Re: 28 Monument Square – Code Violations

Re: Existing Conditions Walk-Thru  
28 Monument Square, Portland, Maine

Code Synopsis: 2009 IBC

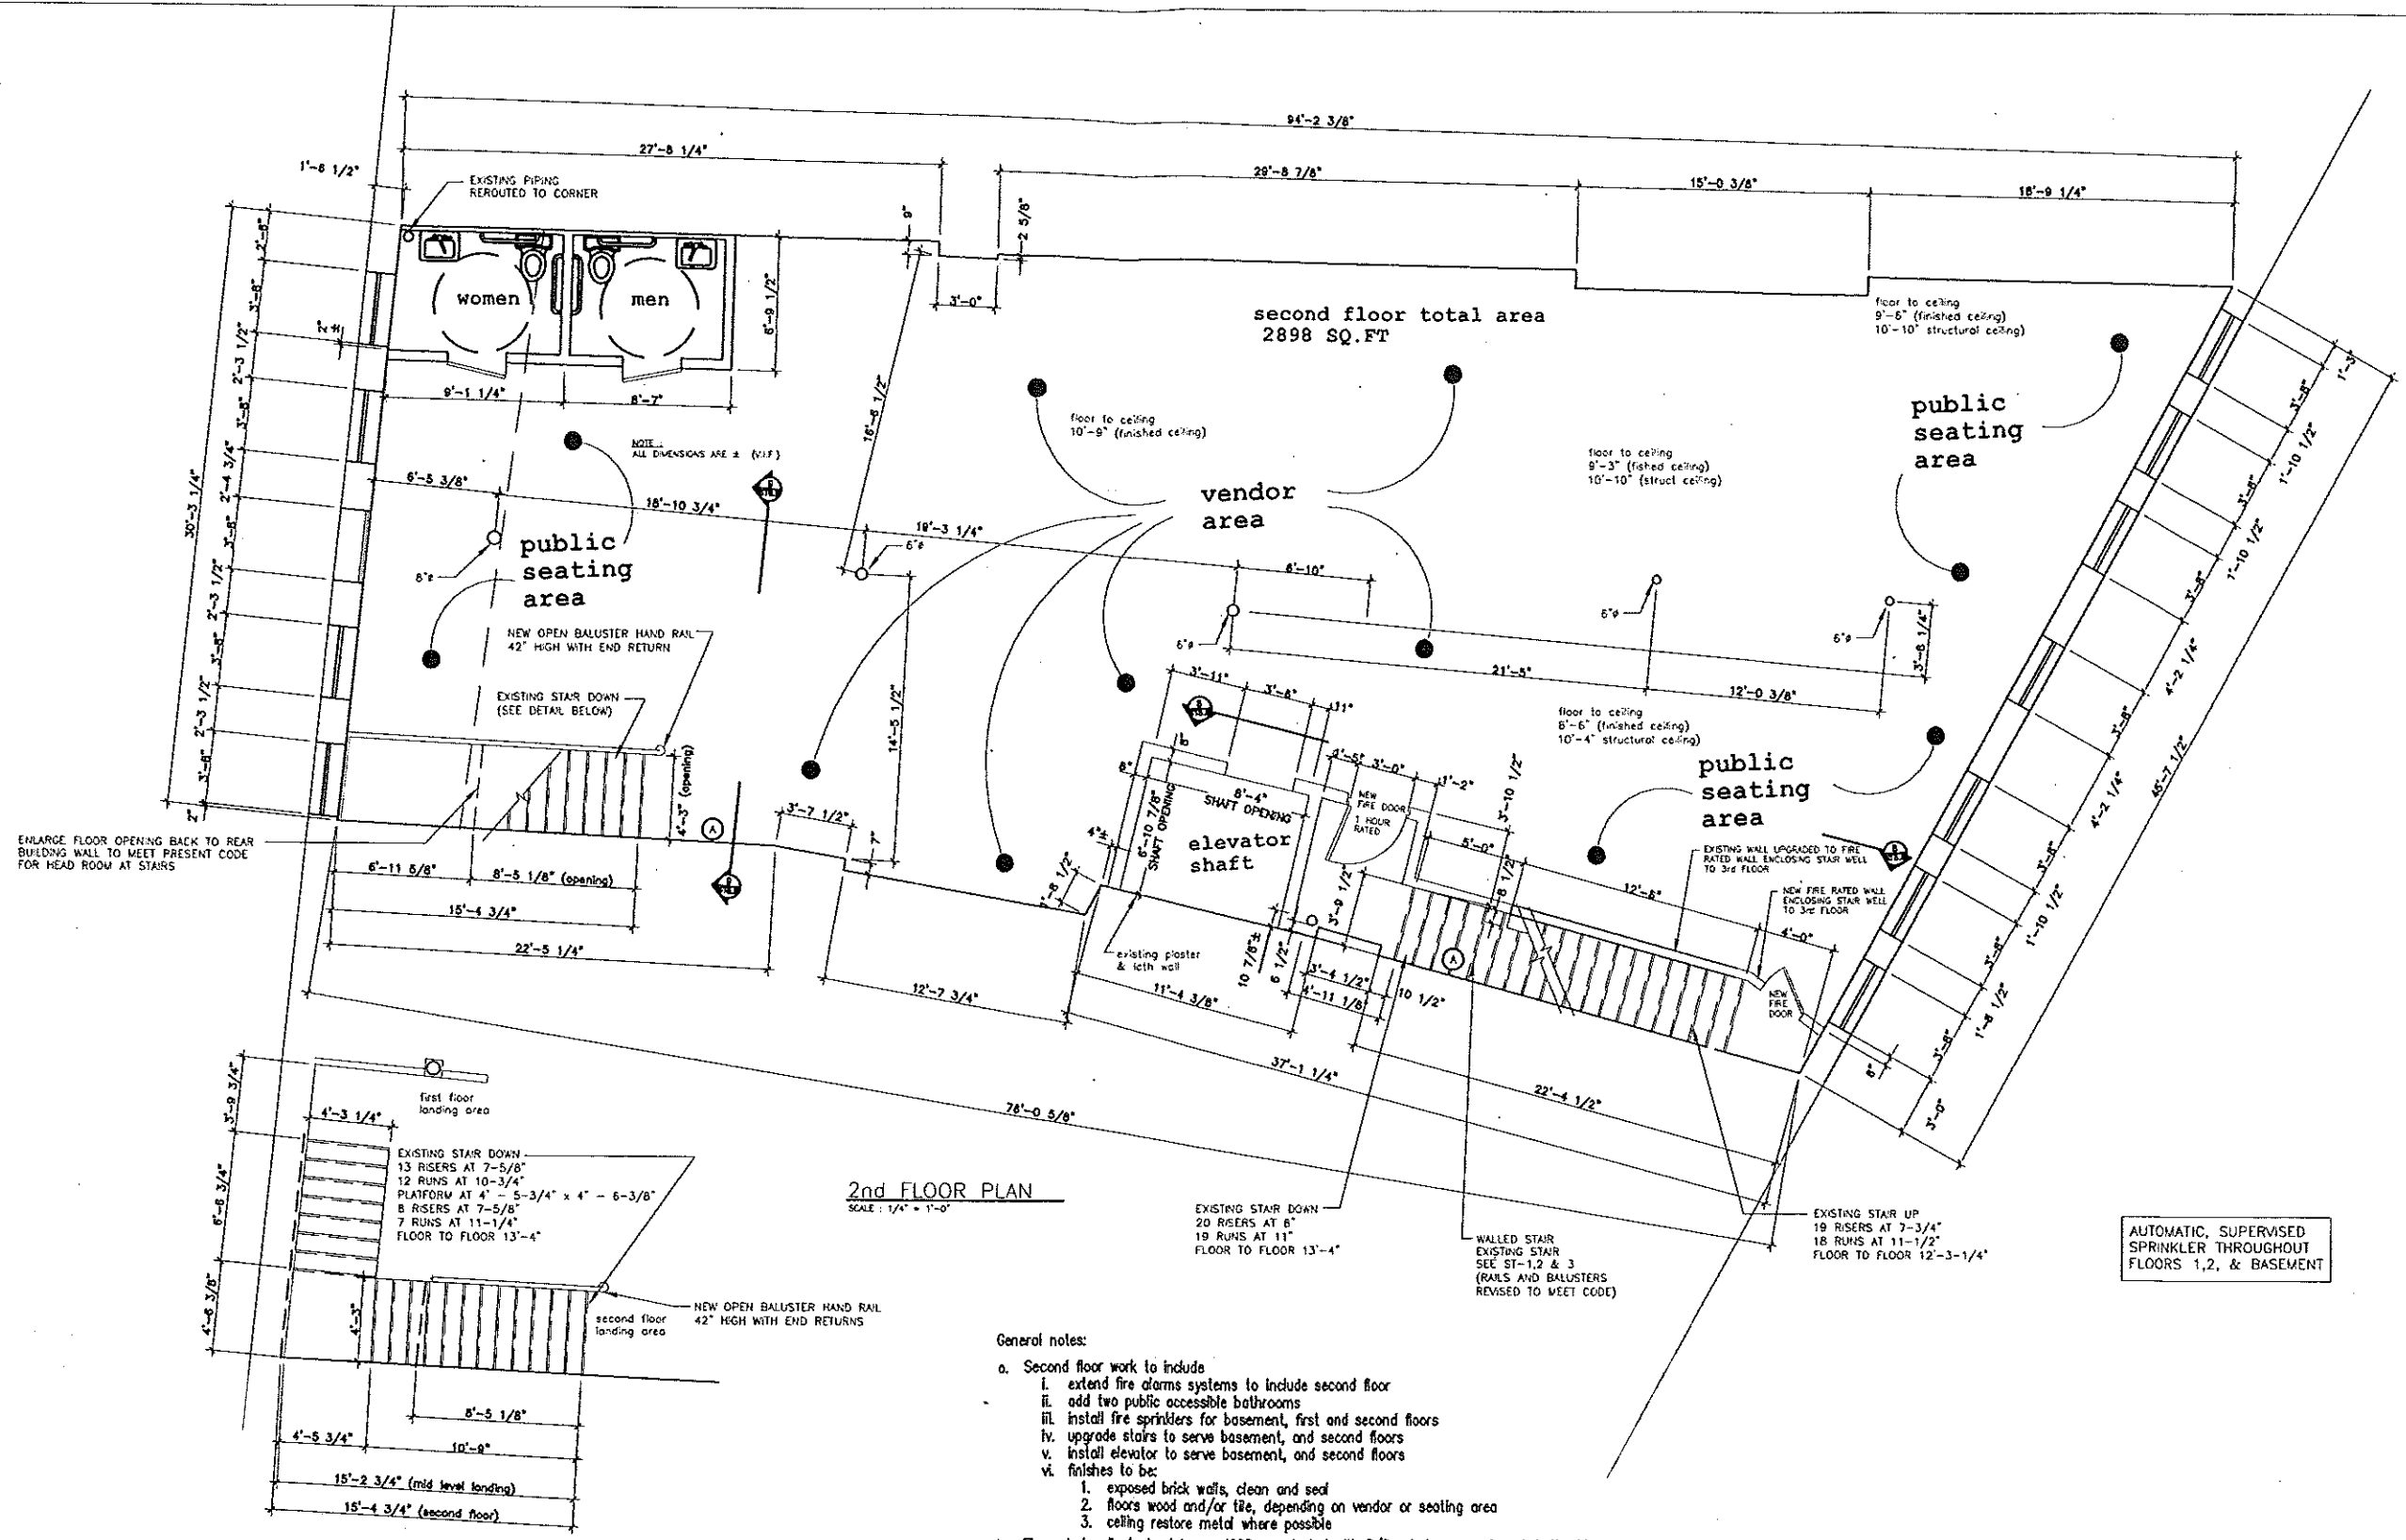
2. An electric range was observed in use with open pan cooking (sautéing) and a large pot (simmering) without the presence of a code-compliant NFPA approved exhaust hood. It appears this activity, in combination with the contributing odors from the lower floors, and item #1 above may be contributing to the cooking odors experienced in the residential units above.

28 Monument Square 1st Floor

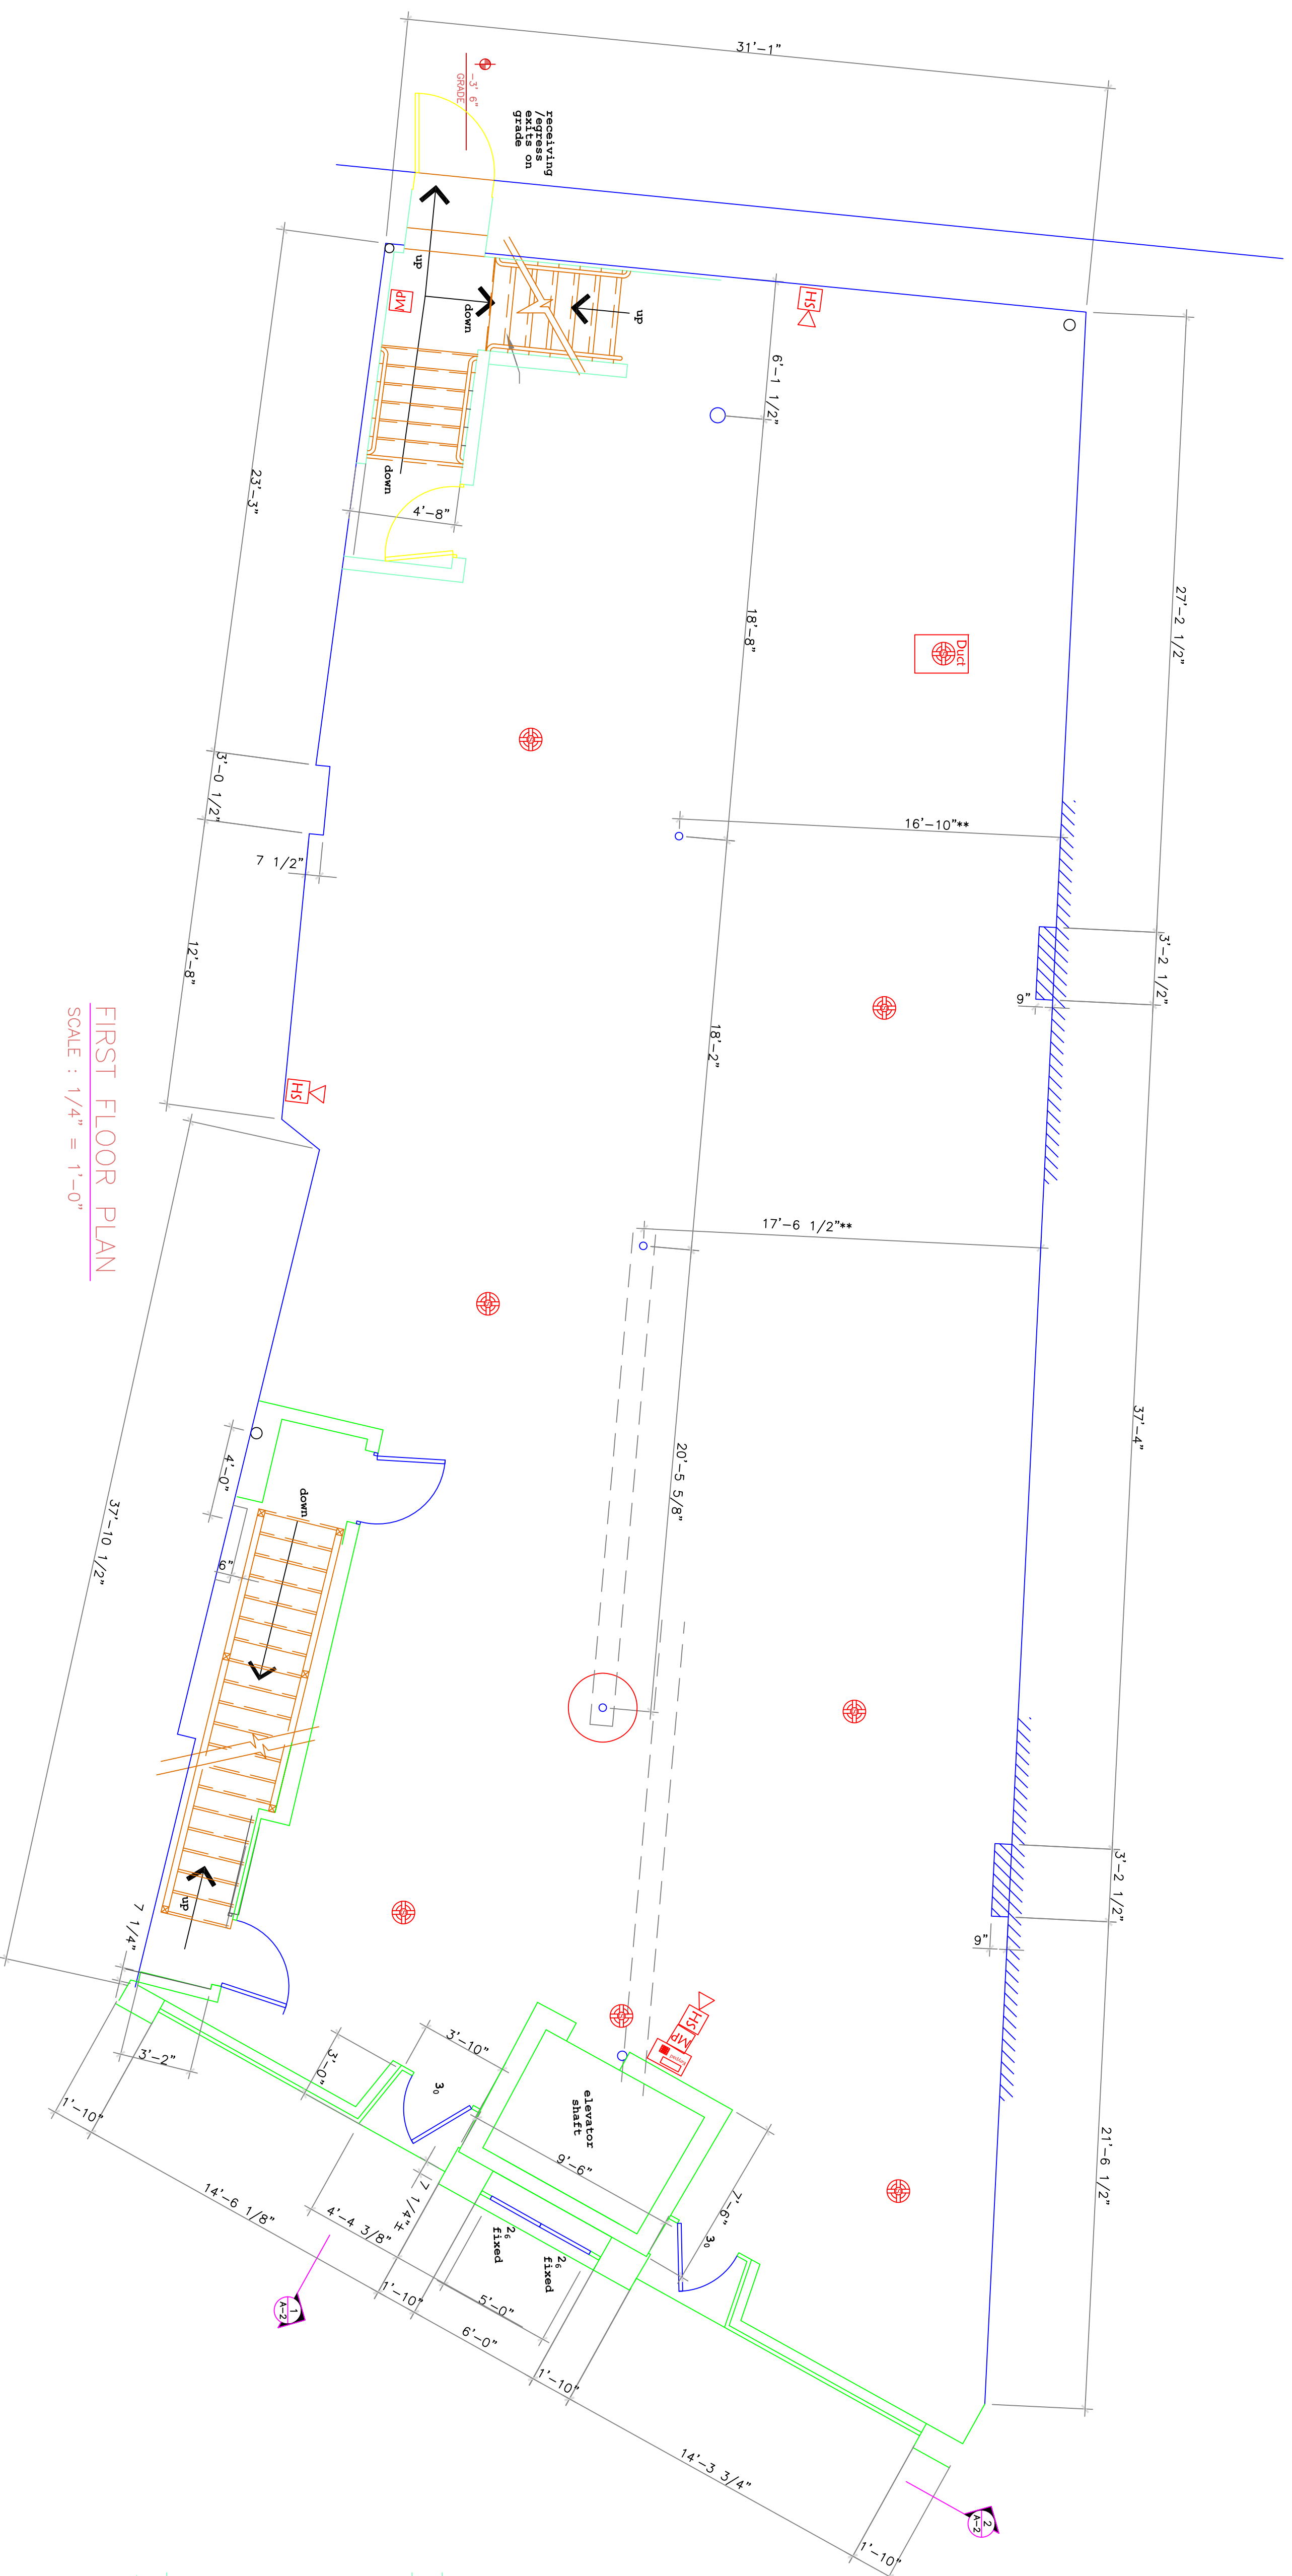
1. There are numerous voids in the ceiling/floor construction assembly along the length of the west masonry wall and the rear/south exterior wall. Additionally, there are multiple areas where pipe/conduit penetrations do not appear to be fully sealed, particularly at the vertical chase at the southwest corner of the building (beer & wine retail space). Again, this may be a contributing factor to the presence of cooking odors detected in the floors above.

3 FLOOR SECTION BETWEEN 2nd & 3rd
ONE HOUR FIRE RATING
SCALE : 1" = 1'-0"

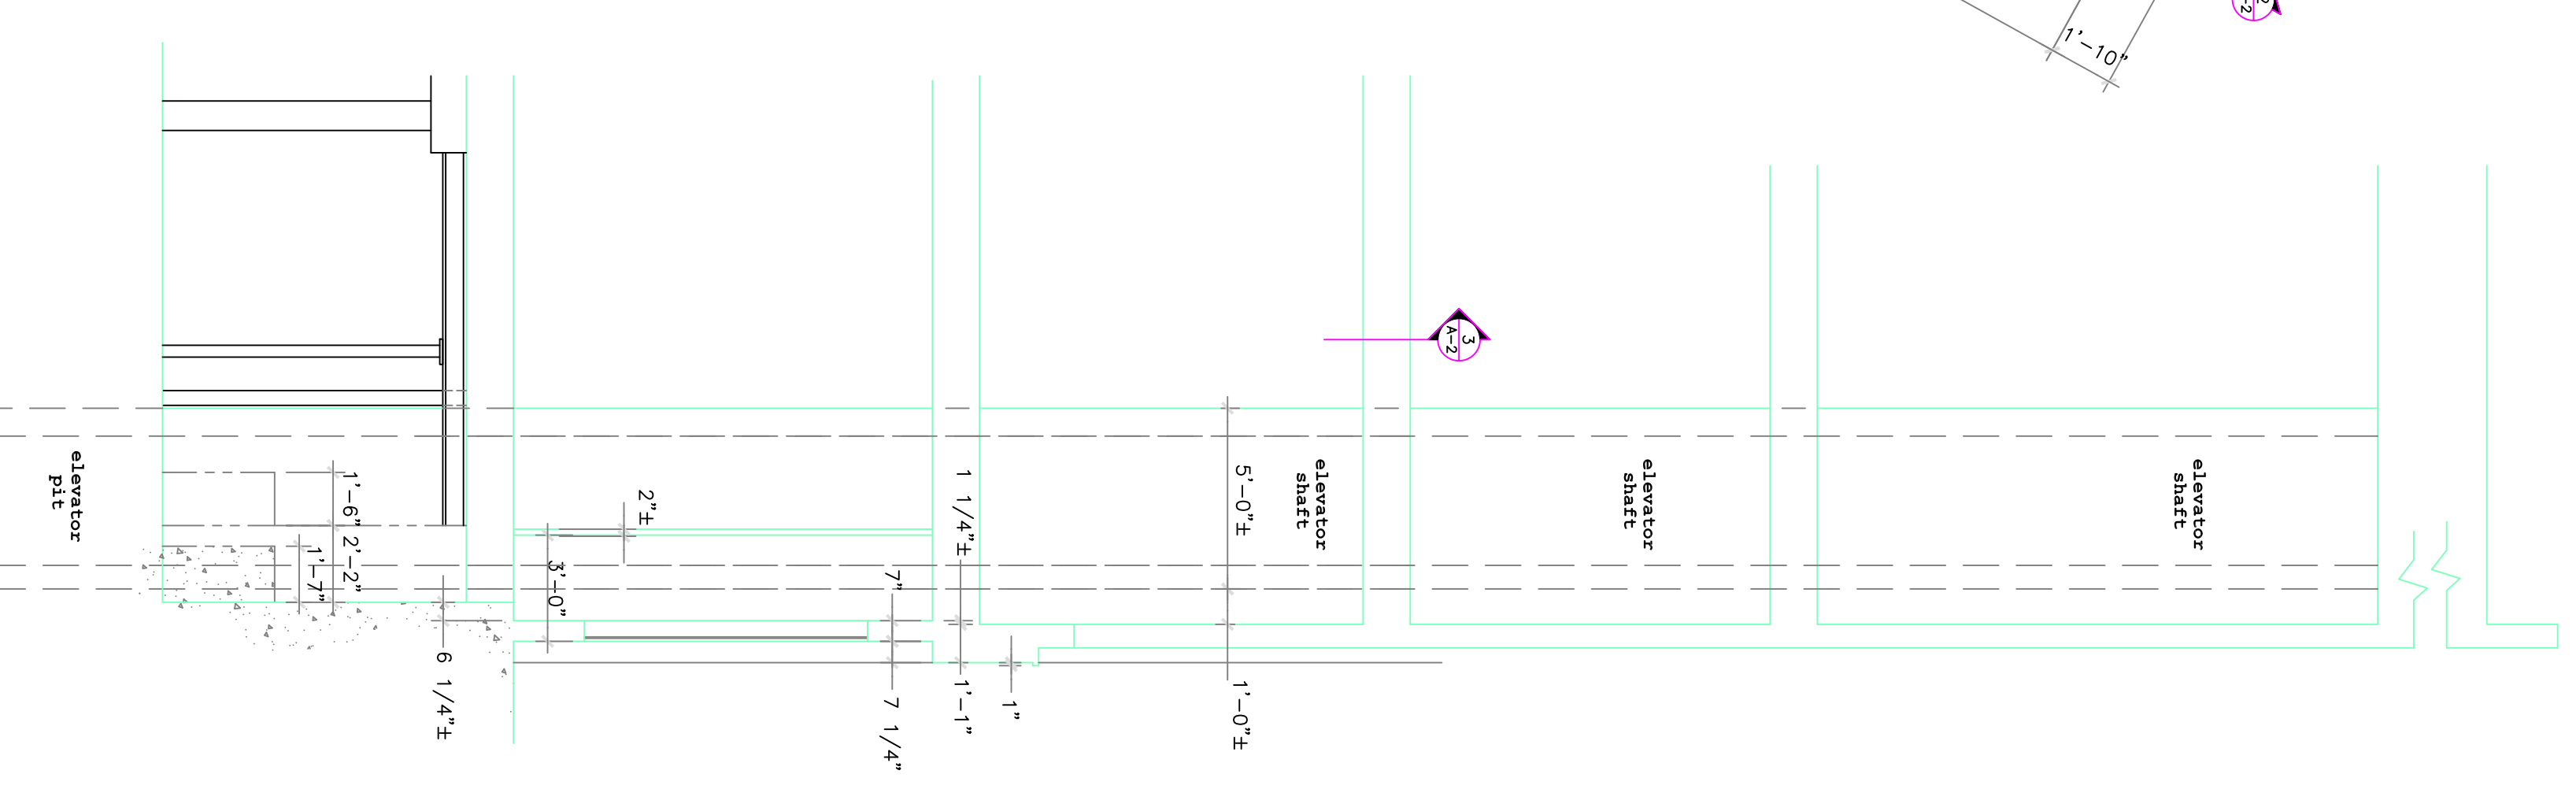
1. The rated fire-separation ceiling/floor construction assembly between the Third floor Residential Condominium and the Second floor Assembly occupancy appears to be incomplete at the masonry perimeter walls. The sheetrock finish has visible voids into the brick shelf/wood framing. Additionally, the utility room pipe/conduit penetrations do not appear to be fully sealed in a workmanlike manner. These voids should be completely sealed for a fully rated one-hour fire separation.
